This is to certify that Ballpark Drive Development /Douglas St. Use
has permission to 58 x 64 New Single Family
AT 0 Ballpark Dr City 371 A041001

RE: Lot #11 Ballpark Drive - #371-A-041- R-2 Zone – application #05-0461

Your permit to construct a new single family dwelling at lot #11 Ballpark Drive has been denied because we have not received all the required submittals in order to determine compliance with City Ordinances.

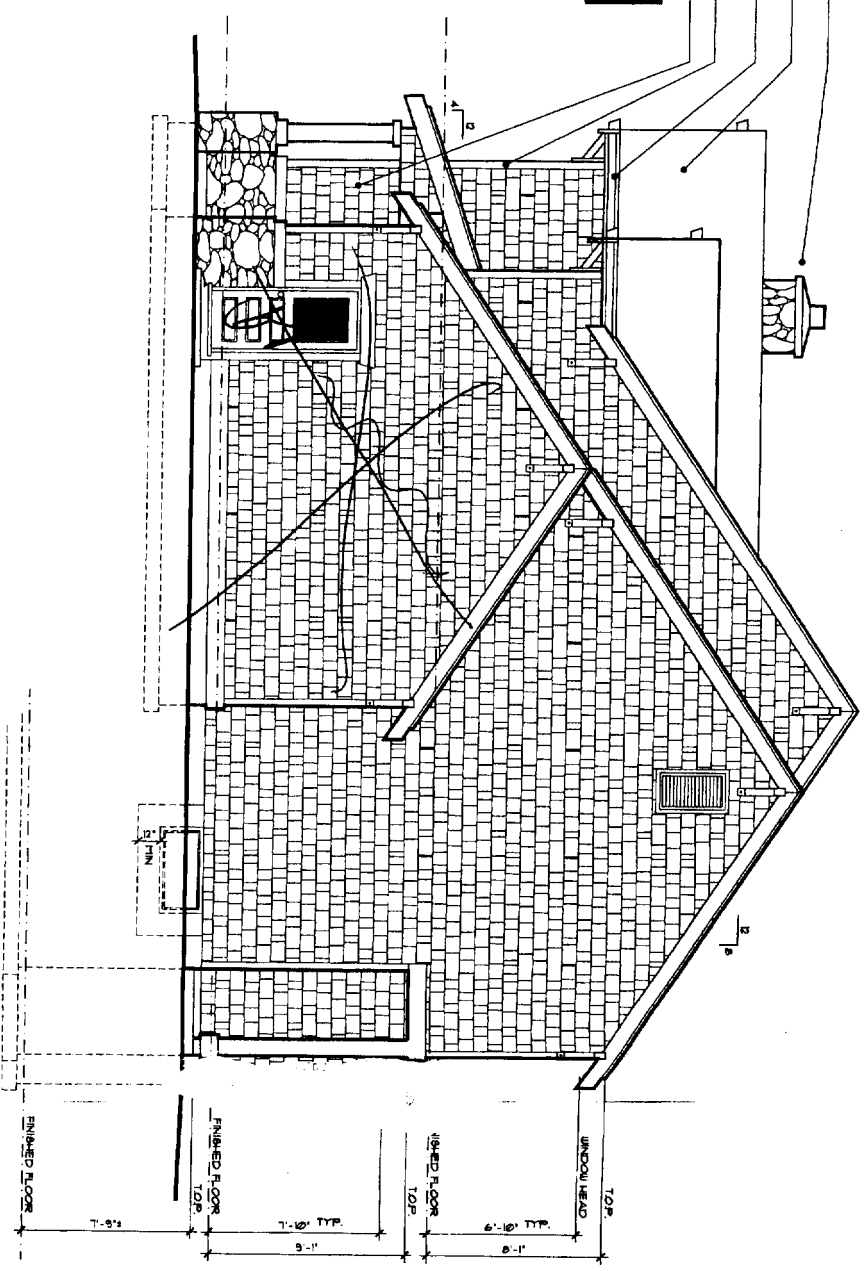
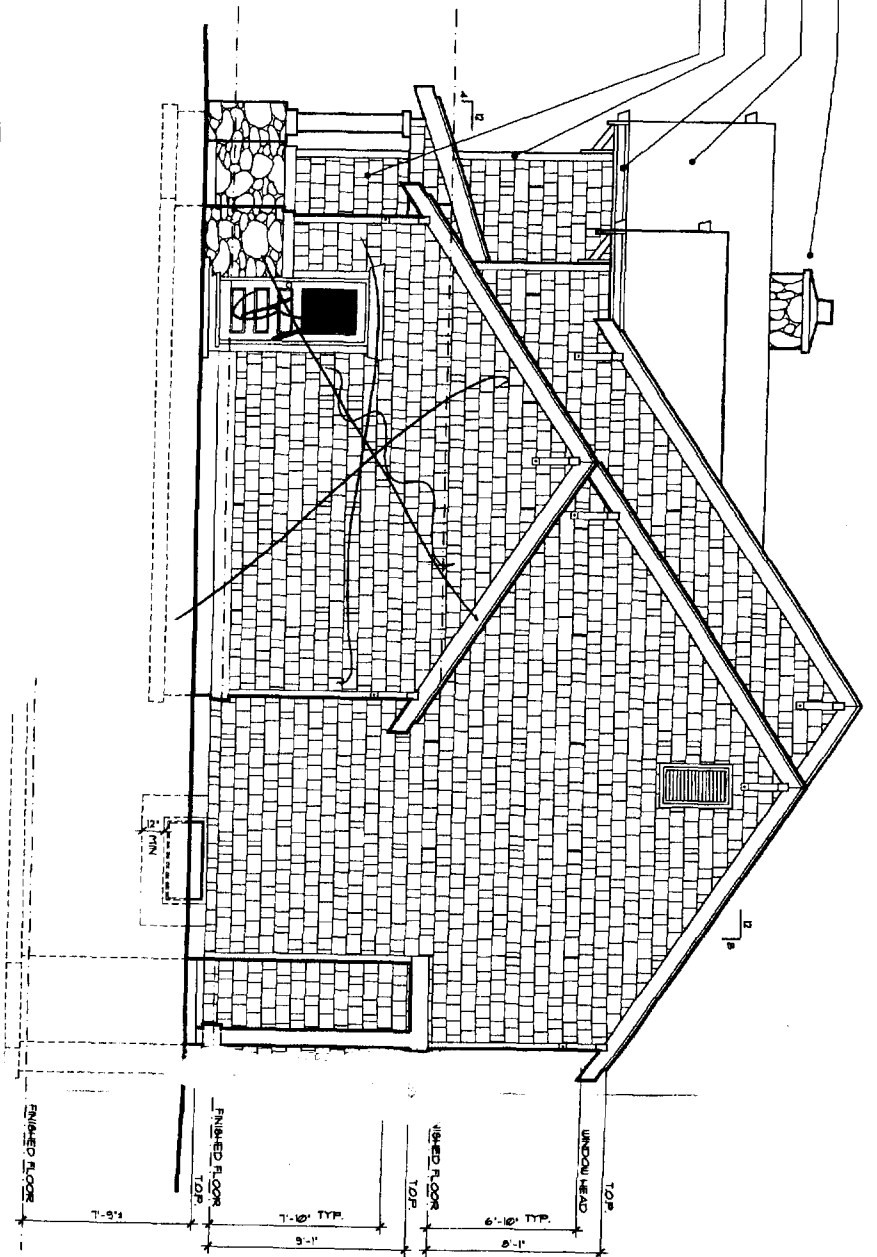
- 3) The design load spec sheets for any engineered beam(s) must be submitted to this office.
- 4) There must be a 2" clearance maintained between the chimney and any combustible material, and fire blocking per code at each level

BALLPARK DRIVE

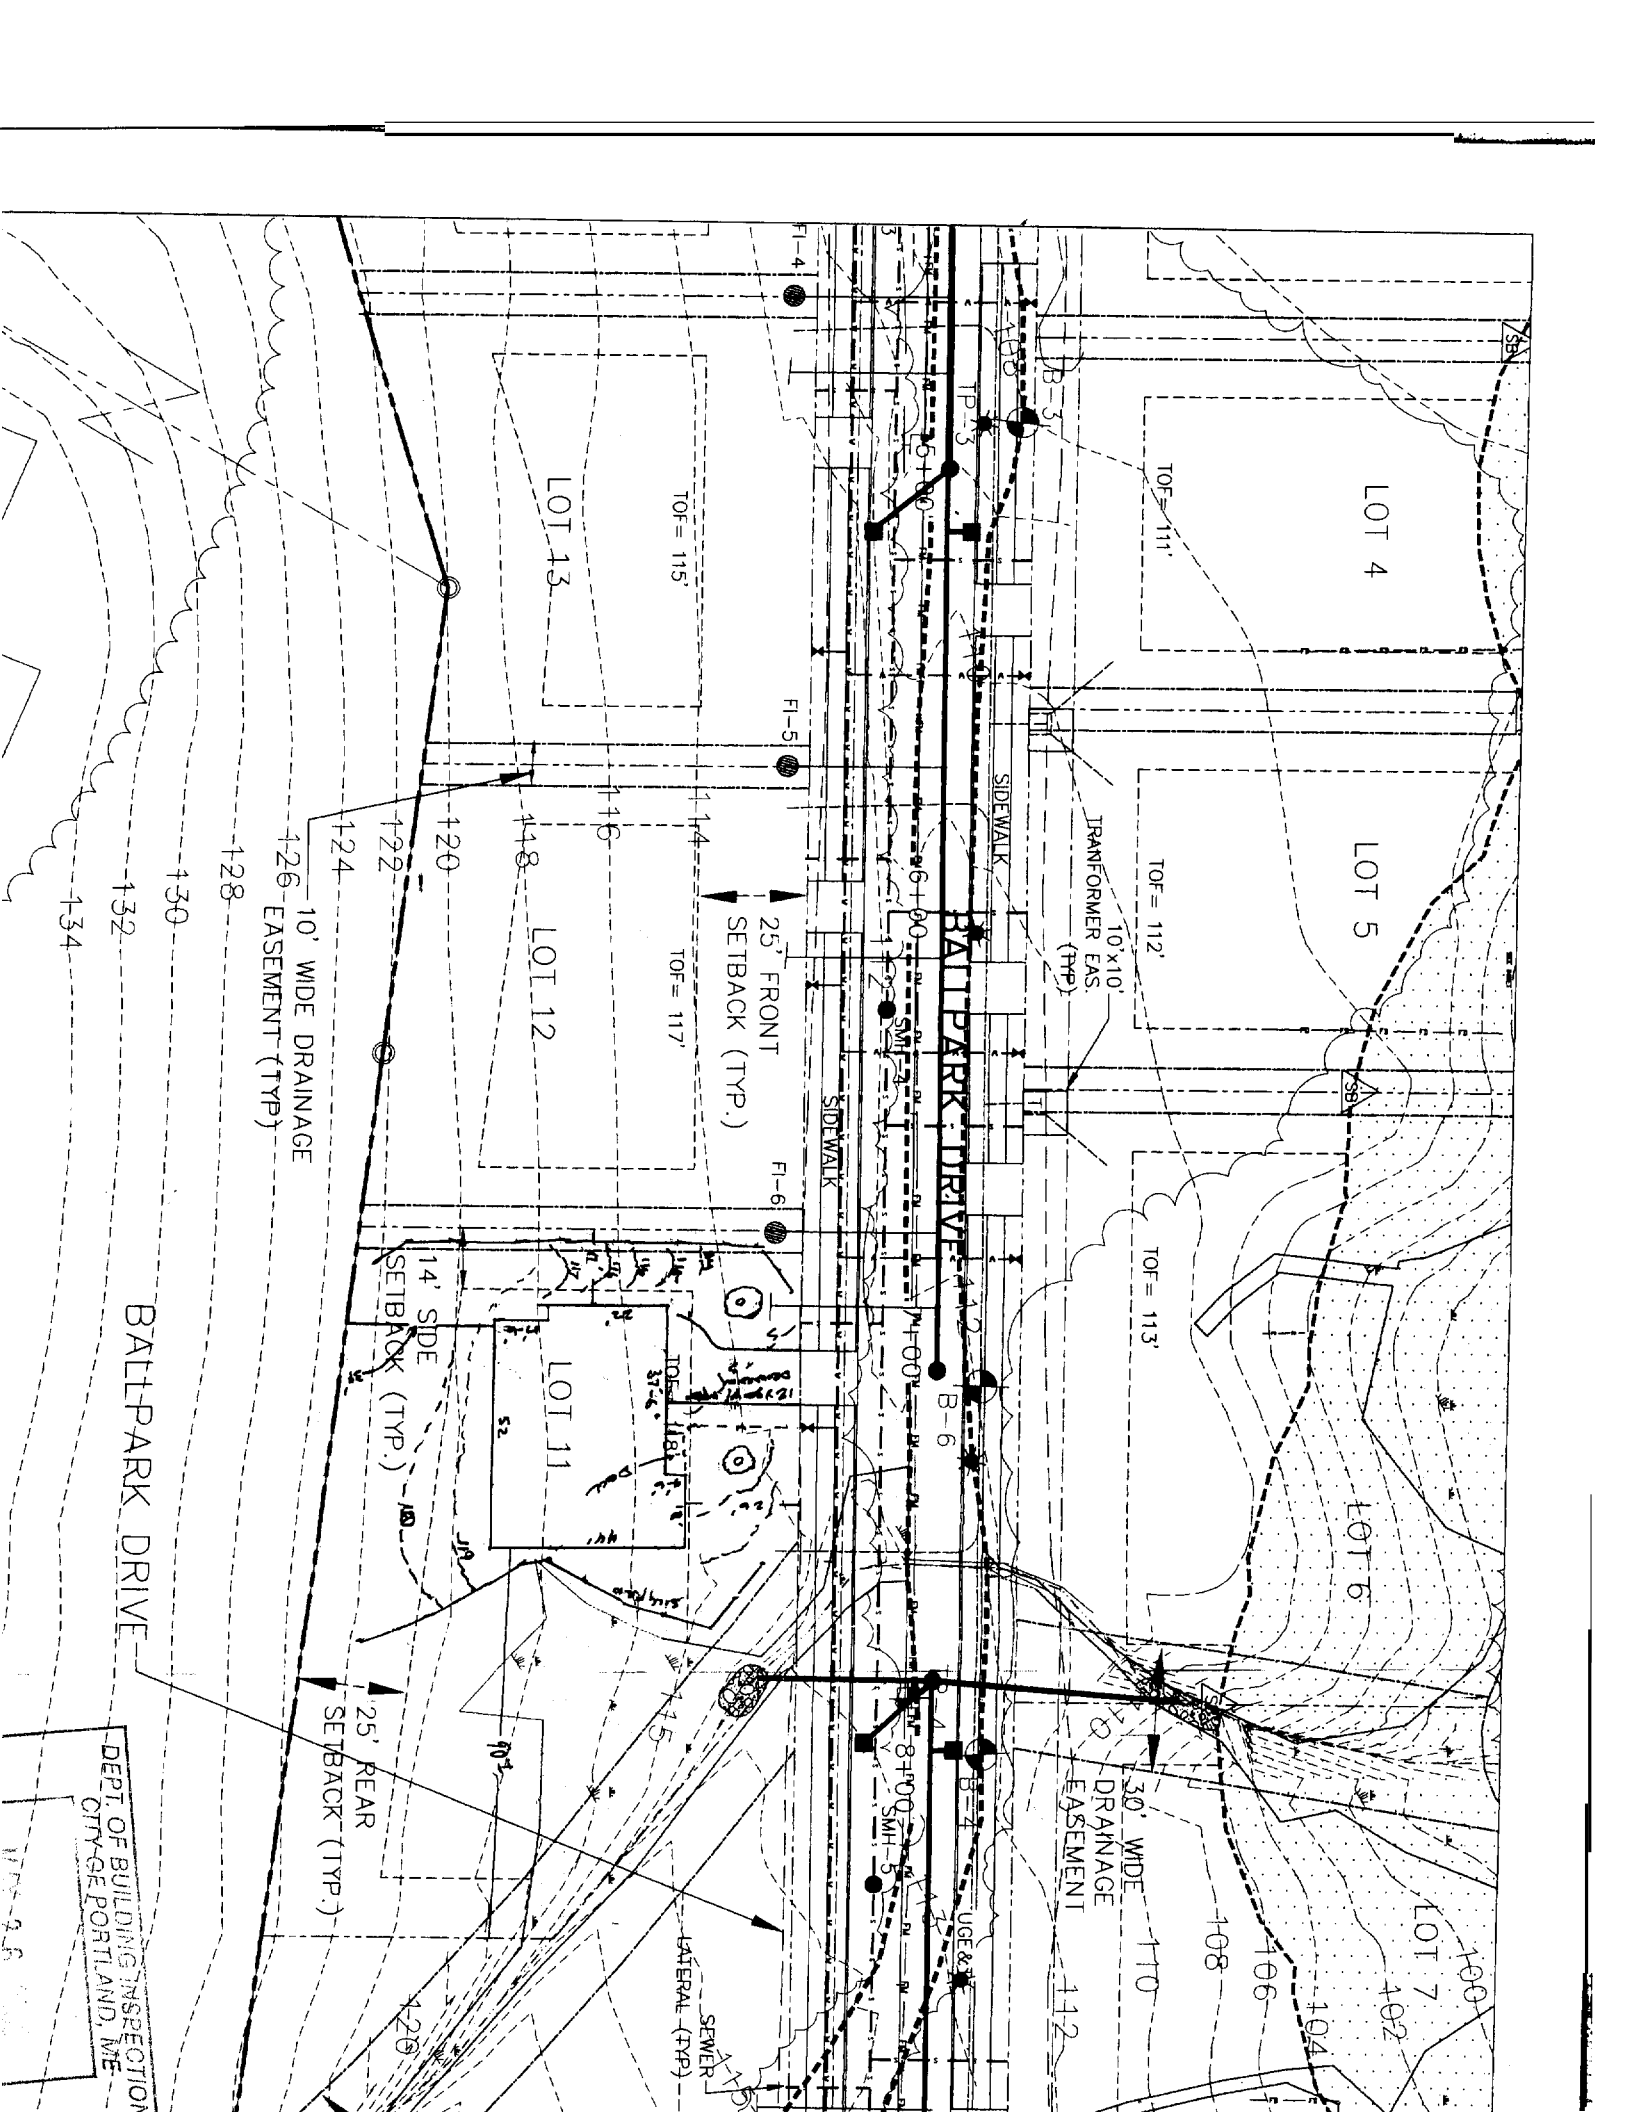
You have not submitted a scaled site plan showing the proposed, dimensioned structure. Your currently submitted site plan does not match your submitted building construction plans. Your site plan must show all projections, including, but not limited to, decks, stairs, chimneys, and bay windows.

→ NO SCALED SITE PLAN SUBMITTED. CAN'T DETERMINE COMPLIANCE - SITE & BLDG PLANS DON'T MATCH
5/26/05 received plans OK

5/26/05 - dropped off new plans - still not showing all projections - chimney - FEMA extension - also present PD for minor/minor site plan review
